Submission Form

Epping to Thornleigh Third Track Proposal. Application number SSI 5132.

I/we object to the Epping to Thornleigh Third Track Proposal and consider that the EIS is inadequate and does not address the full impact of this proposal. It will cause untold damage to the health of residents and to the fabric of the Beecroft Cheltenham Heritage Conservation Area. Do not approve this project, reconsider the alternatives and protect the community.

Figure 5.6 Cross-section and elevation - New Cheltenham Station concourse building
Note: Indicatively added to future design

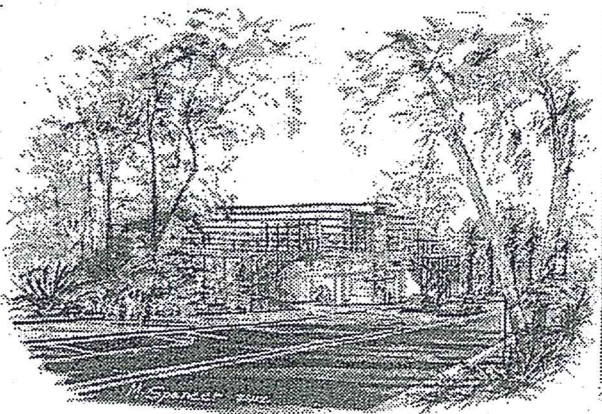
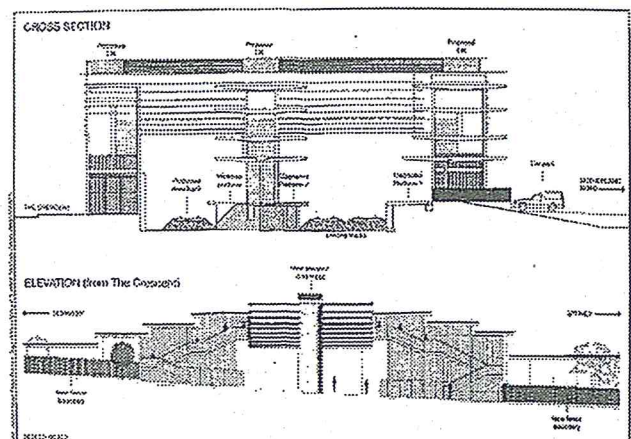
- The proposed redevelopment of Cheltenham Station shows no regard for the HCA. The visual impact of the proposed 13m high glass and steel concourse is totally unacceptable in this HCA.

Concept design drawing of proposed changes to Beecroft Station (Parsons Brinckerhoff 9/3/12). Former side platform shaded in pink.

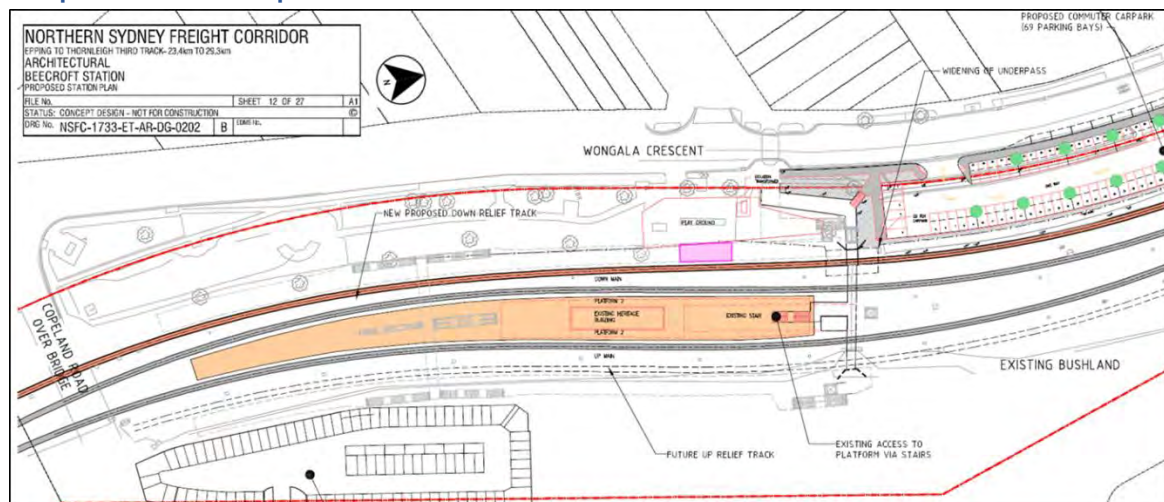
- There has been inadequate assessment of the project's impact on the fabric of the Beecroft Cheltenham Heritage Conservation Area (HCA).
- The plan given for Beecroft Railway station Precinct is vague. The relationship to the trees, playground and original 1895 platform located south of the present station is not shown. A fourth track is shown on the eastern side. The plan does not include urgently needed lifts to allow disabled access at Beecroft Station.

- Beecroft Station Gardens have a heritage listing with Hornsby Council but the impact on them has not been adequately addressed. No arborist's report is given for the trees which will be removed.
